# Appeal Decision

**Appeal Ref: APP/T2350/A/13/2191378**

**Fell View, Barnacre Road, Longridge, Preston PR3 2PD**

- The appeal is made under section 78 of the Town and Country Planning Act 1990 against a refusal to grant outline planning permission.
  - The appeal is made by Mr M and Mrs S Patel and Mr F Moosa against the decision of Ribble Valley Borough Council.
  - The application Ref 3/2012/0862, dated 18 April 2012, was refused by notice dated 20 November 2012.
  - The development proposed is 9 dwellings.
-

SCALE
1:500 @ d3
7504-P20

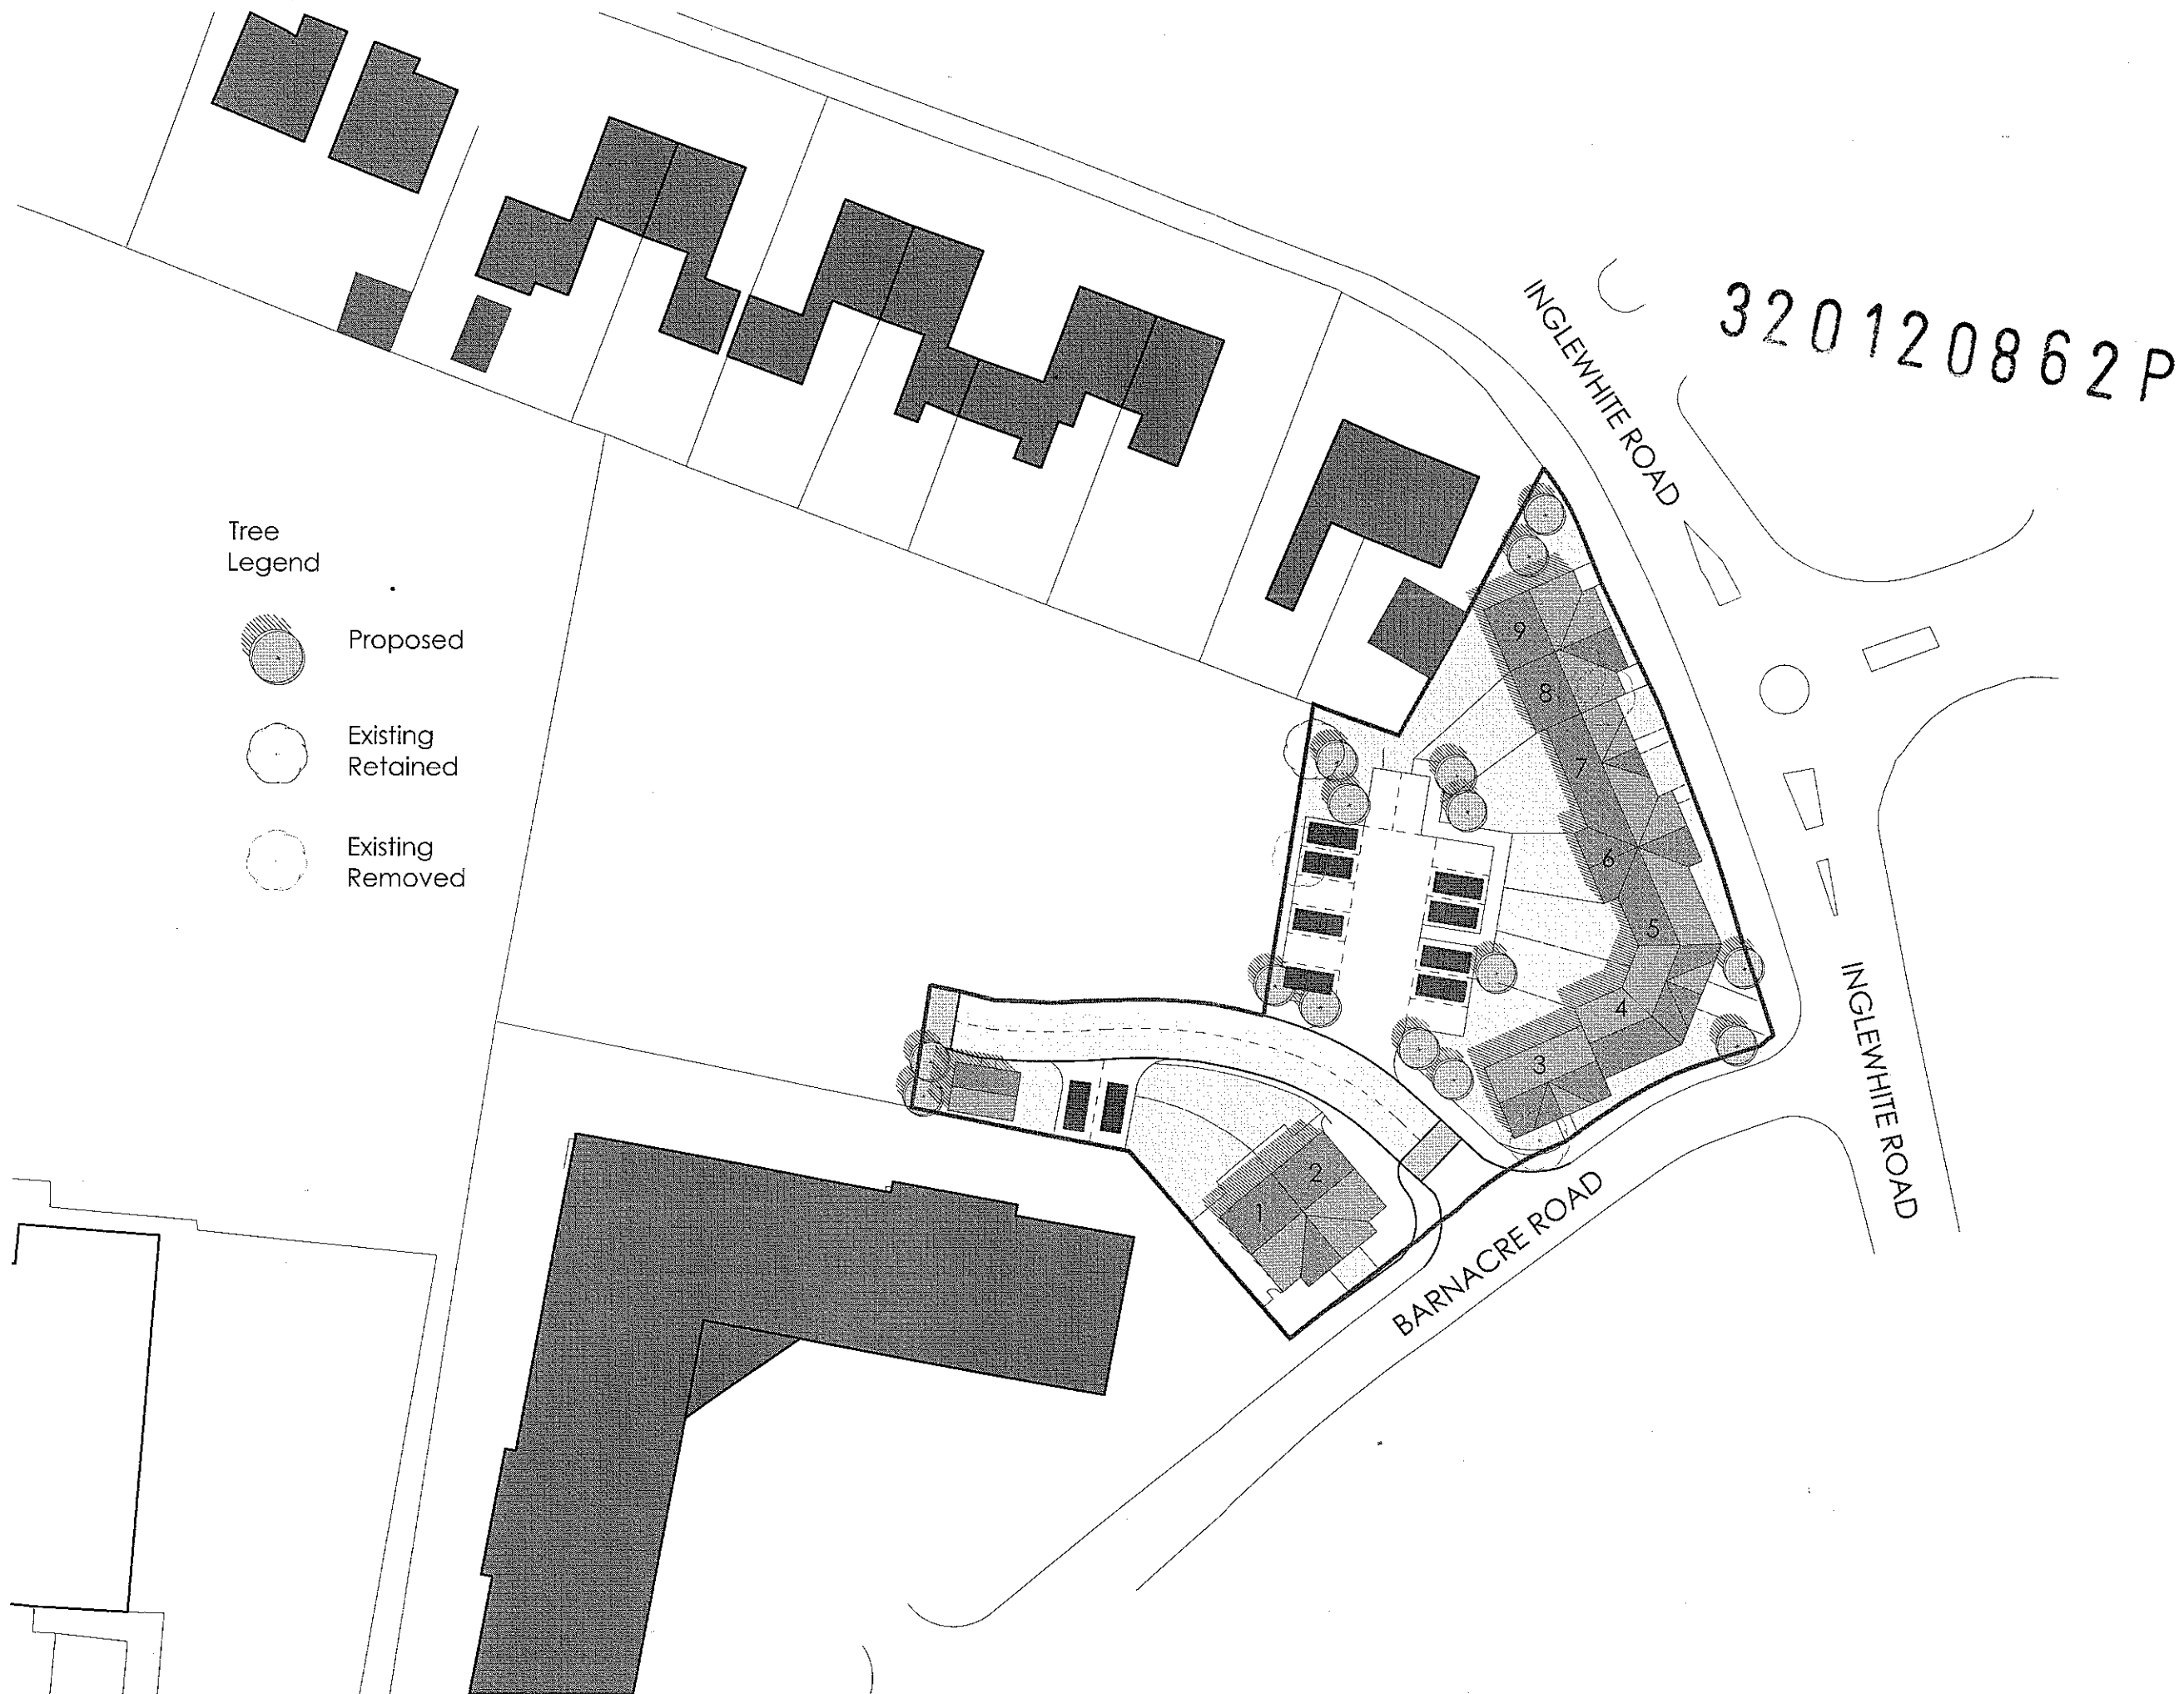
5. The proposed development would consist of a pair of semi-detached houses on the far side of the access road on Barnacre Road and a terrace of 7 properties that would be situated along the corner of Barnacre and Inglewhite Road. Despite the presence of similar dwellings to the south, the terraced nature of the development and its location close to the pavement with only small front gardens would, in my view, result in a scheme that would not reflect the more suburban character of the area immediately surrounding the appeal site. In contrast to the open and spacious feel of the surrounding residential area, I consider the development would appear cramped and over developed which would have a detrimental impact on the appearance of the area.

10. By virtue of being located at the point where the terrace turns the corner, the rear elevations of plots 4 and 5 of the proposal would be angled towards each other. As a result windows in the rear elevation in these dwellings would directly face the rear gardens of the neighbouring property. Whilst at ground floor level it is probable that the boundary treatment between the properties would be sufficient to prevent any overlooking, this would not be the case at first floor level.
11. Whilst I accept that in most terraced and semi-detached dwellings first floor windows are afforded some views into neighbouring gardens I consider that the relative position of these two dwellings means that the level of overlooking would be much greater. Consequently areas of the garden closest to the property which are generally not possible to see from neighbouring properties

15. No 63 has a kitchen window located on its side elevation which would be facing the side elevation of the dwelling on plot 9. Although the appearance of the dwellings is a reserved matter I am satisfied that it would be possible to design a dwelling so that there would be no loss of privacy to this window in No 63.

16. The windows in the rear elevation of plot 9 would overlook the rear garden of No 63 in particular. No 63 has an attached garage located to the rear of the property on the boundary with the appeal site. I consider that this, together with the probable boundary treatment, would restrict any views into the rear garden from ground floor windows in the proposed dwelling. I accept that at first floor levels views into the rear garden of both No 63 and No 65 would be possible. However, such views would be of the bottom of the rear gardens furthest away from the house. In addition the overlooking that would be created would be no worse than the overlooking that already exists between these two properties at present.
